Application Ref:	3/2026/0509			 Ribble Valley Borough Council www.ribblevalley.gov.uk
Date Inspected:	N/A	Site Notice:	N/A	
Officer:	LOH			
DELEGATED ITEM FILE REPORT:				APPROVAL

Development Description:	Certificate of Lawfulness for proposed single storey side extension and extension of existing rear dormer.
Site Address/Location:	25 The Hazels, Wilpshire, BB1 9HZ

Mr M Gregory				
25 The Hazels, Wilpshire. Plans and Elevations As Proposed		Drwg No.	Rev.	
		A4919-PL02		
		Scale	Sheet Size	
		As Shown	A1	
		Date	June 2026	
		Drawn	Checked	Approved
		DME

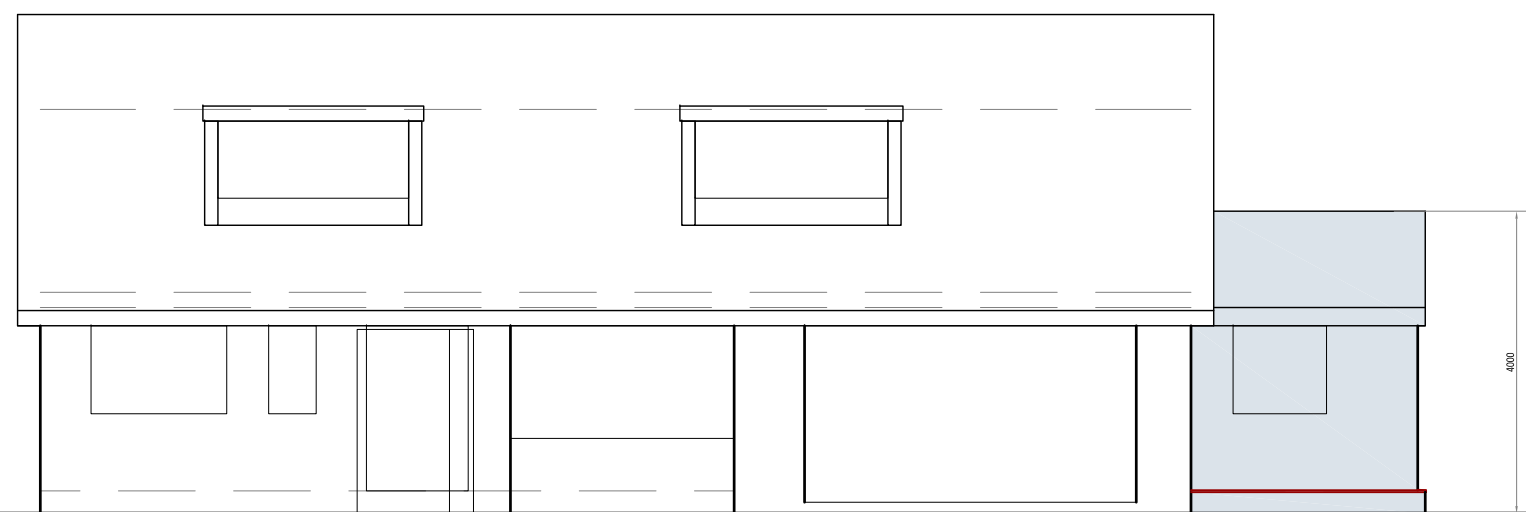
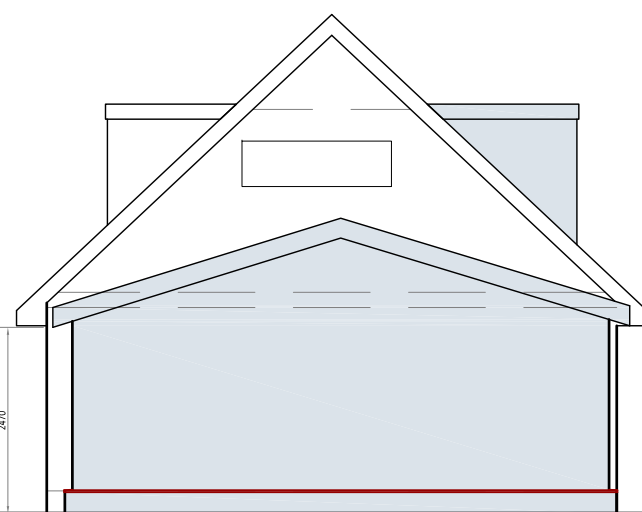
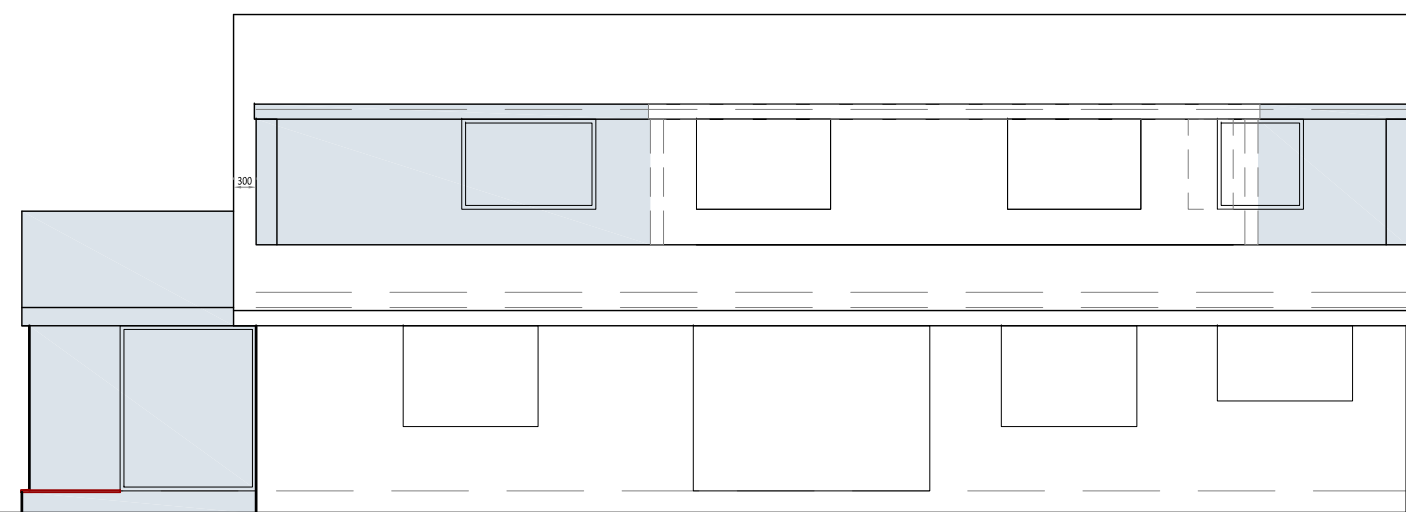
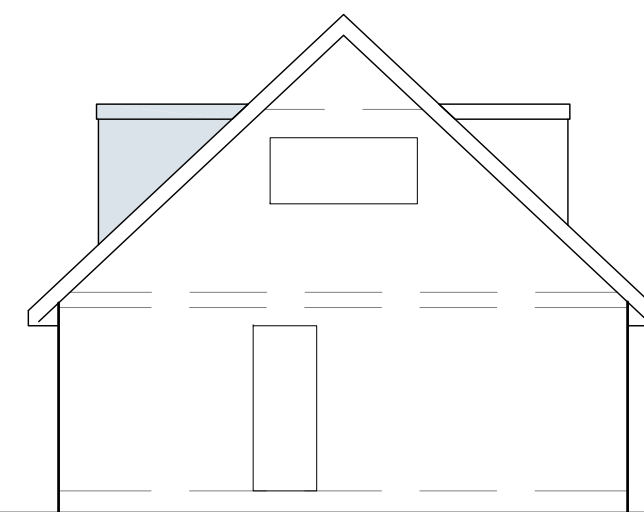
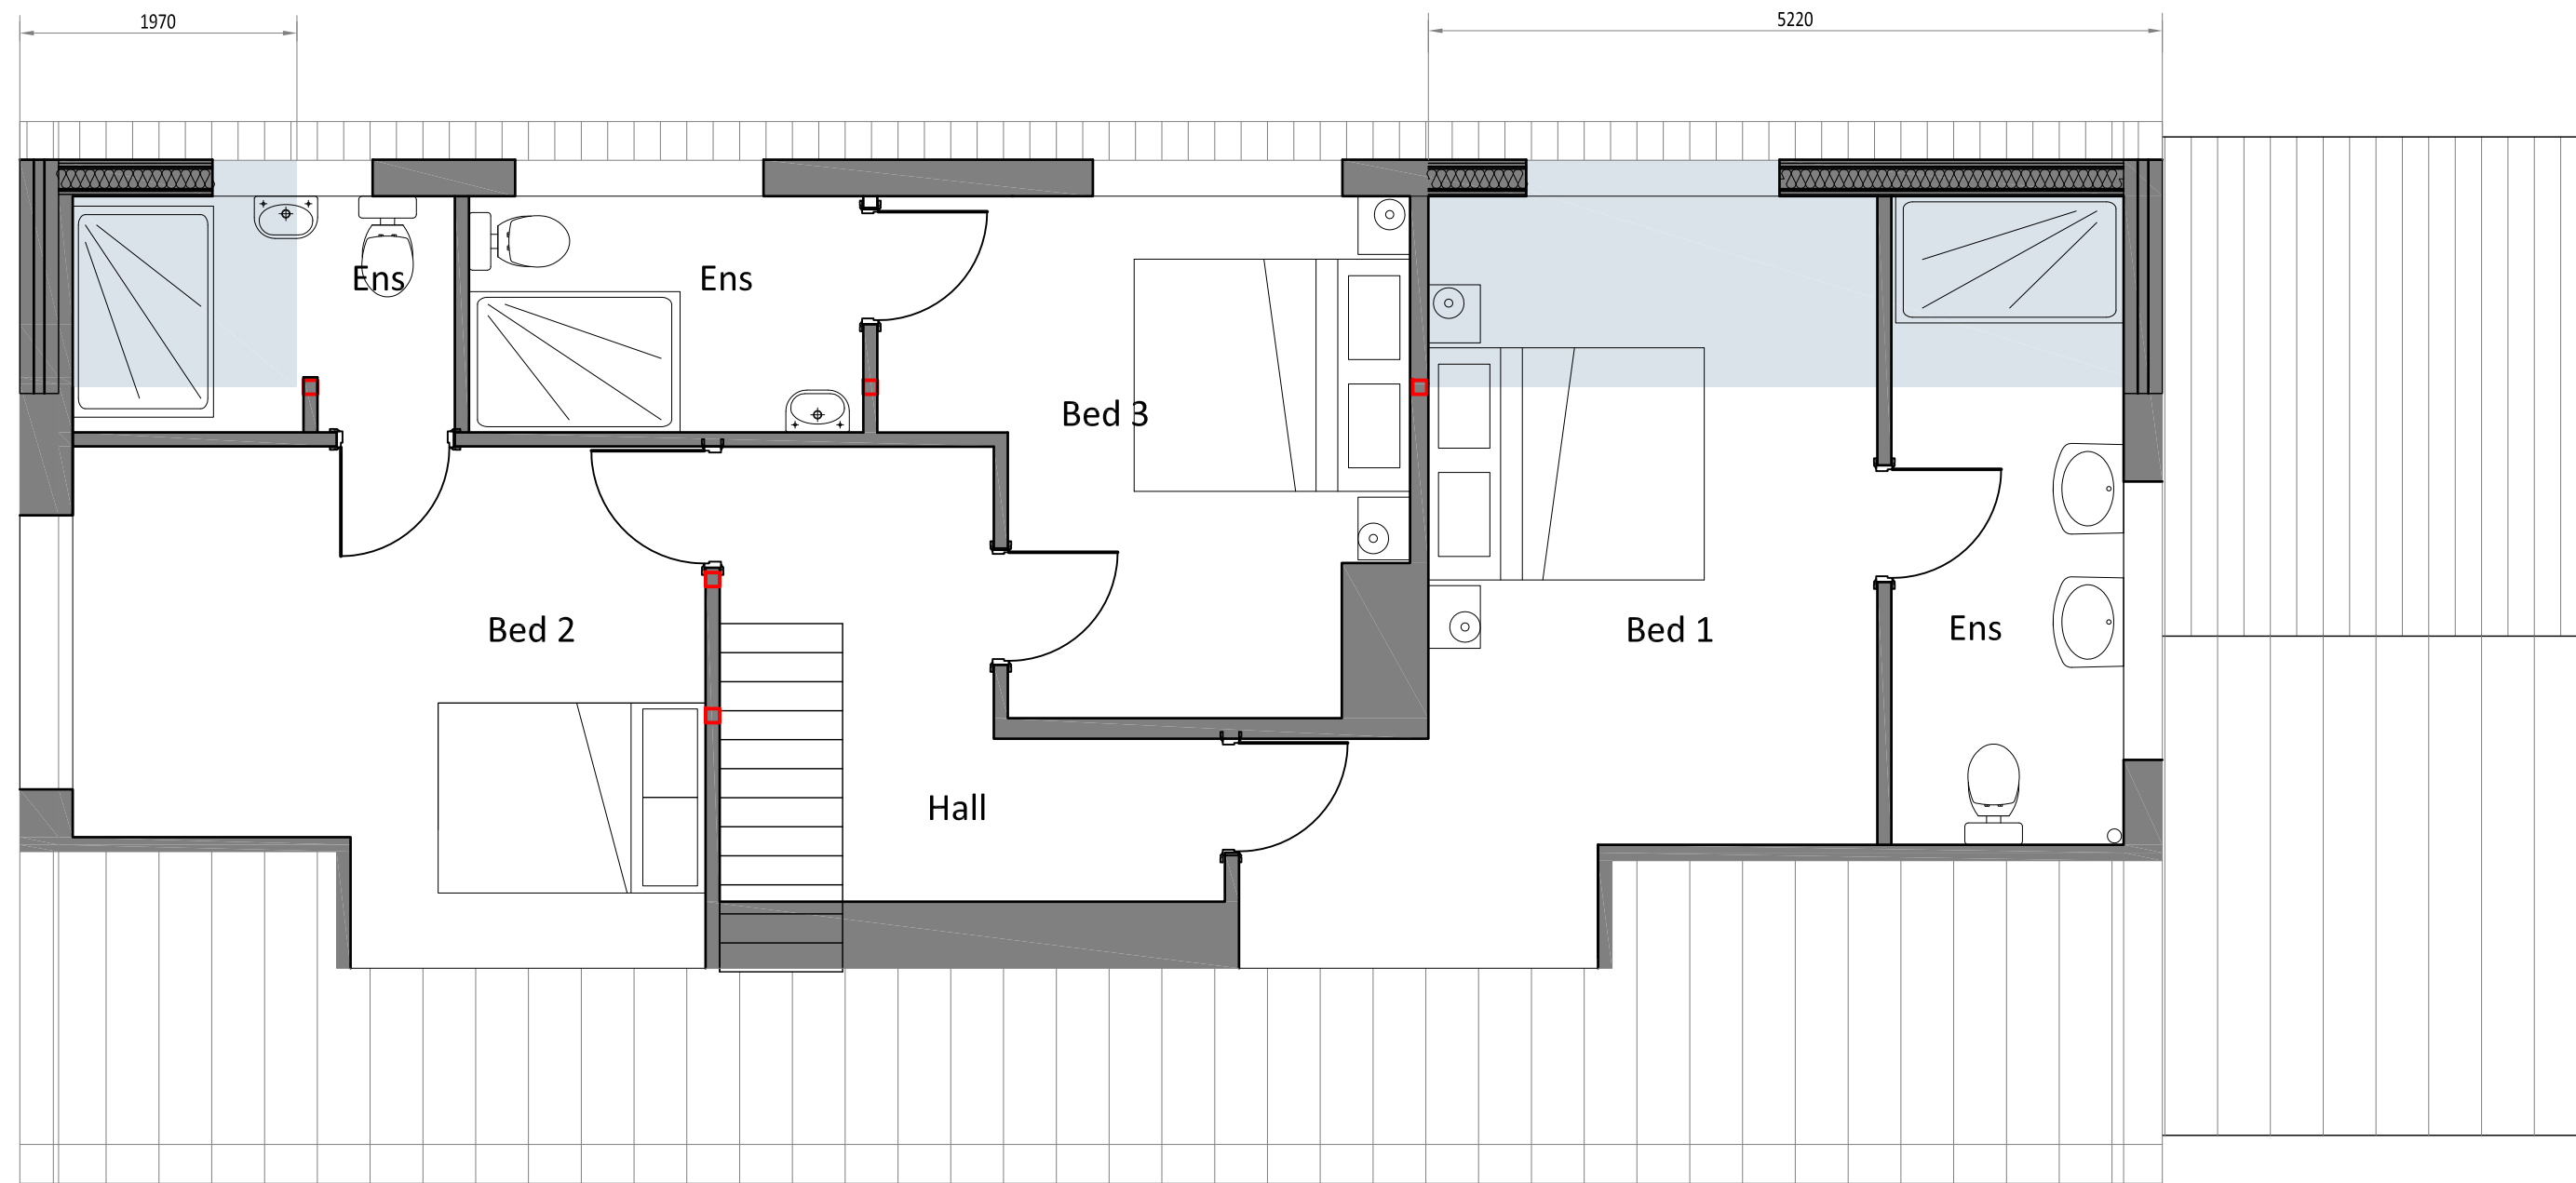
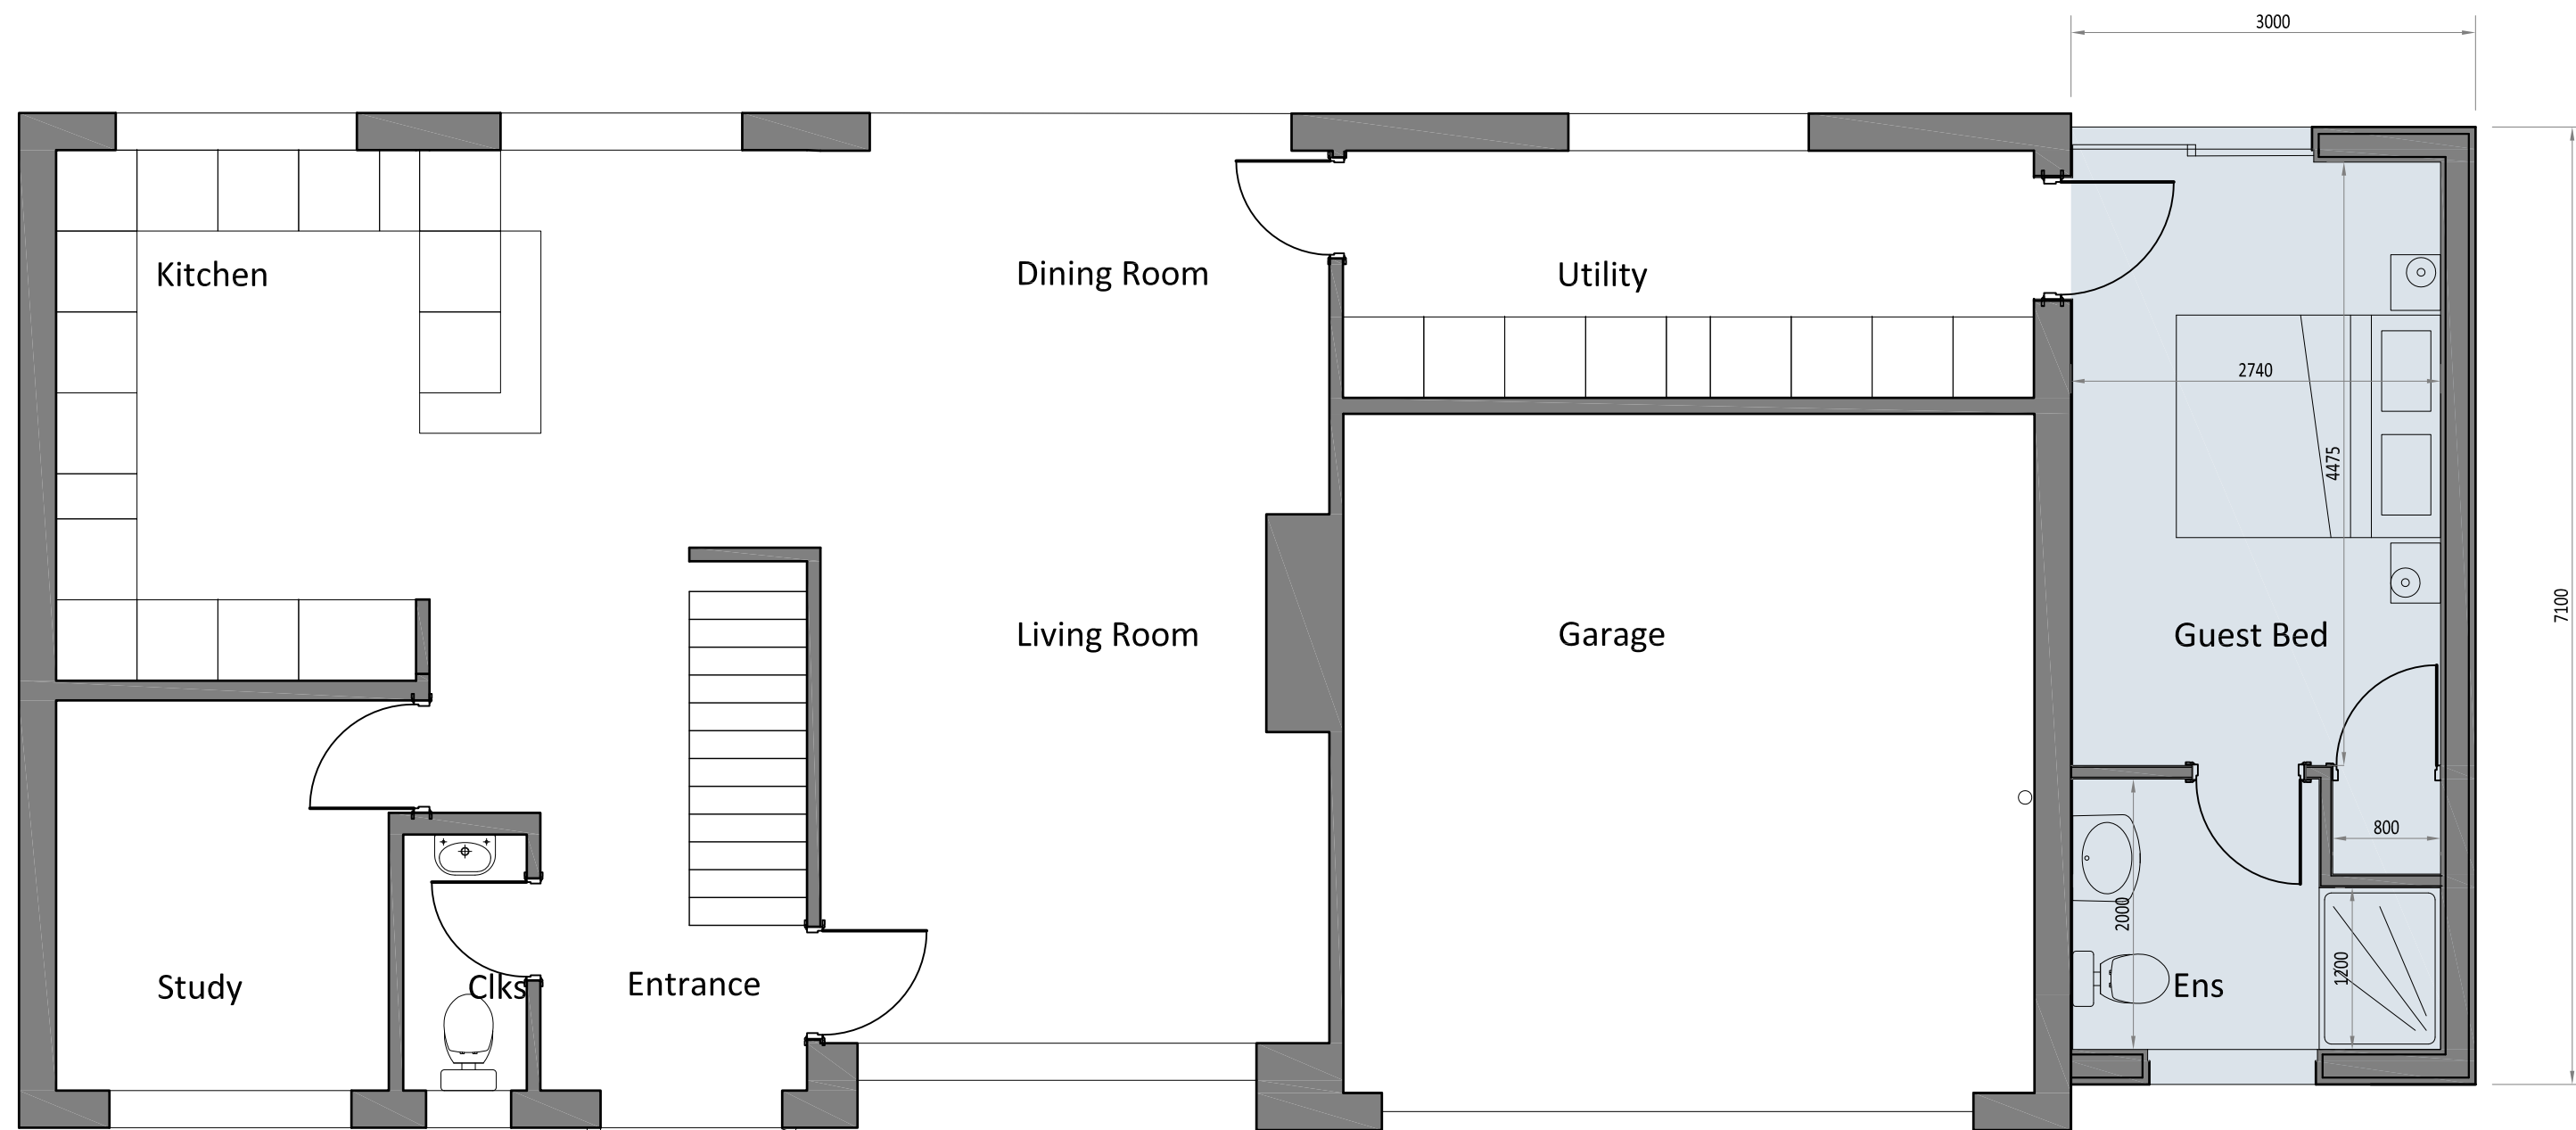
Consent is sought for a proposed single-storey side extension projecting from the east side elevation with a width of 3m and a length of 7.1m. The proposal features a pitched roof design with an eaves and ridge height of 2.4m and 4m respectively. An extension of the existing rear dormer is also proposed.

With respect to materiality, the side extension would be rendered and have roof tiles to match the existing dwelling. The rear dormer extension would be tile hung to match the existing rear dormer.

The proposed single storey side extension would not exceed 50% of the total area of the curtilage of the property.

The height of the proposed single storey side extension would not exceed the height of the existing dwelling.

The height of the eaves of the proposed extension would not exceed the height of the eaves of the existing dwellinghouse.

The proposed single storey side extension would not extend beyond a wall which forms the principal elevation of the original dwellinghouse or fronts a highway and forms a side elevation of the original dwellinghouse.

The proposed single storey side extension does not extend beyond the rear elevation of the original dwelling by more than 4m or exceed 4m in height.

The proposed single storey side extension does not extend beyond the rear elevation of the original dwelling by more than 8m or exceed 4m in height.

The enlarged part of the dwellinghouse would be within 2 metres of the boundary of its curtilage however the height of the eaves of the enlarged part would not exceed 3 metres.

The enlarged part of the dwellinghouse would extend beyond a wall forming a side elevation of the original dwellinghouse however, would not exceed 4m in height, would not have more than a single storey and does not have a width greater than half the width of the original dwellinghouse.

The proposed extension includes an alteration to part of the roof of the dwellinghouse and will be subject to the limitations and conditions set out in Class B.

The proposed extension of the rear roof dormer would not exceed the height of the highest part of the existing roof.

The proposed rear roof dormer extension would not exceed 50 cubic metres in volume.

The eaves of the original roof are maintained and the proposed edge of the enlargement closest to the eaves of the original roof, are not less than 0.2m from the eaves.

No part of the proposed enlargement extends beyond the outside face of any external wall of the original dwellinghouse.

The proposed extension of the rear dormer does not include any windows on a wall or roof slope forming a side elevation of the dwellinghouse.

The proposed works constitute permitted development under The Town and Country Planning

(General Permitted Development) (England) Order 2015 Schedule 2, Part 1, Class A and B
subject to the conditions outlined in A.3 and B.2 of this Part.

To approve the application for a Certificate of Lawfulness.
